I strongly object to the approval of SSD 7056. Please see my three original submissions regarding the issues it poses. The applicants' recent responses (May 2016) show that they have done little to address these and worse still, that at least some of their consultants, have not considered them worthy of a response. The submission which follows is my specific response to this amended SSD application.

The amended application retains the same misleading title, 'Remediation, Restoration and Adaptive Re-Use of Campbell's Stores'. It thus continues to hide the fact that a significant part of the proposal relates to a proposed new four-storey-high building in a space that earlier decision makers determined should be left vacant or, at the most, allow a sun protection

DIAGRAM: Proposed Massing

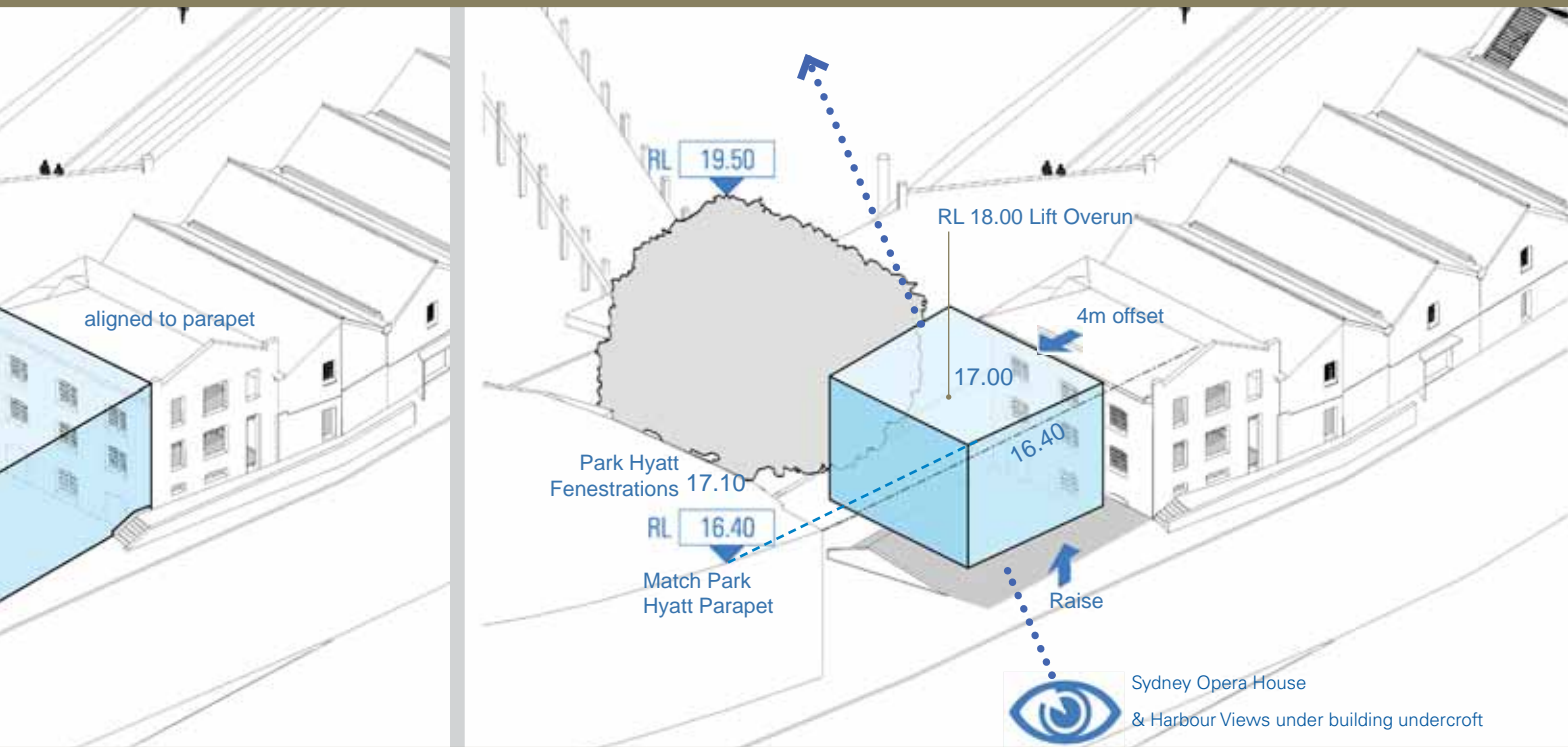
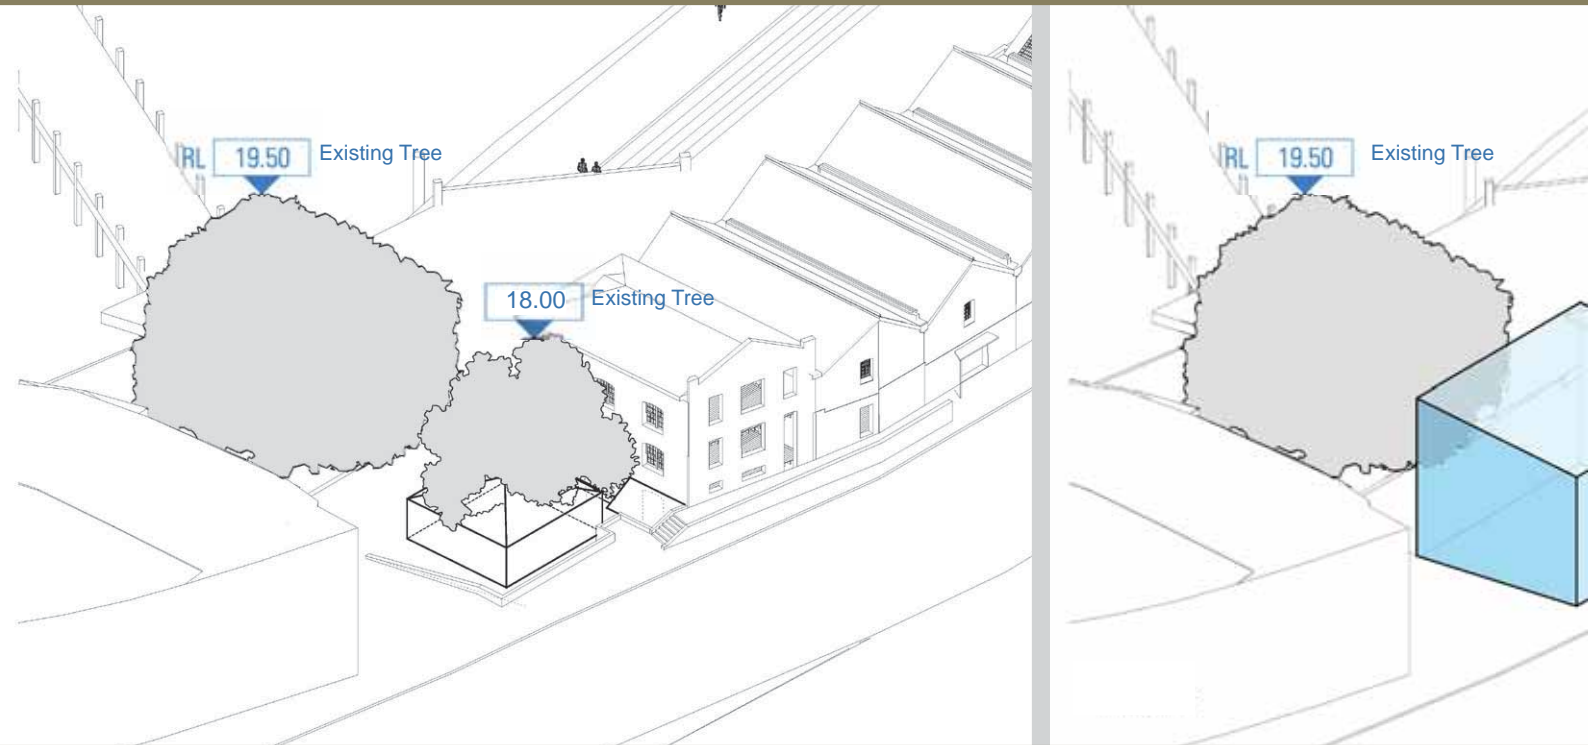
The 'glass box' is the worst of the applicants' proposals and the amended SSD application does little to address criticisms of it. Effectively a bulky glass box on stilts, the proposed new building, even with its reduced height, would still dominate the Hickson Rd streetscape and the Campbell's Cove foreshore. It would have no visual or aesthetic relationship with Campbell's Stores on one side of it or the sympathetic, modern lines of the Park Hyatt Hotel on the other. It would look like it had been parachuted in and create a sense of crowding and over-development in what was intended as open space. The applicants' images misleadingly depict the building as transparent; in reality you wouldn't be able to see through it at all.

The glass box would be a dominant, unattractive addition to the heritage foreshore. Figure 13, p.35 of Submissions Response SSD 7056 and Figures 6.13, 6.15 and 6.16 of pp. 25-27 of the Appendix B1 Design Response Report, Part 3 clearly show this. The box would create an impression of density and scale out of keeping with The Rocks' character and a sense of overdevelopment by restricting the rhythm of space to built form along both the foreshore and the Hickson Rd streetscape. To accommodate this rhythm, it should be no higher than the gutter level of Bay 11 and two metres narrower, but even then it would be out of place here.
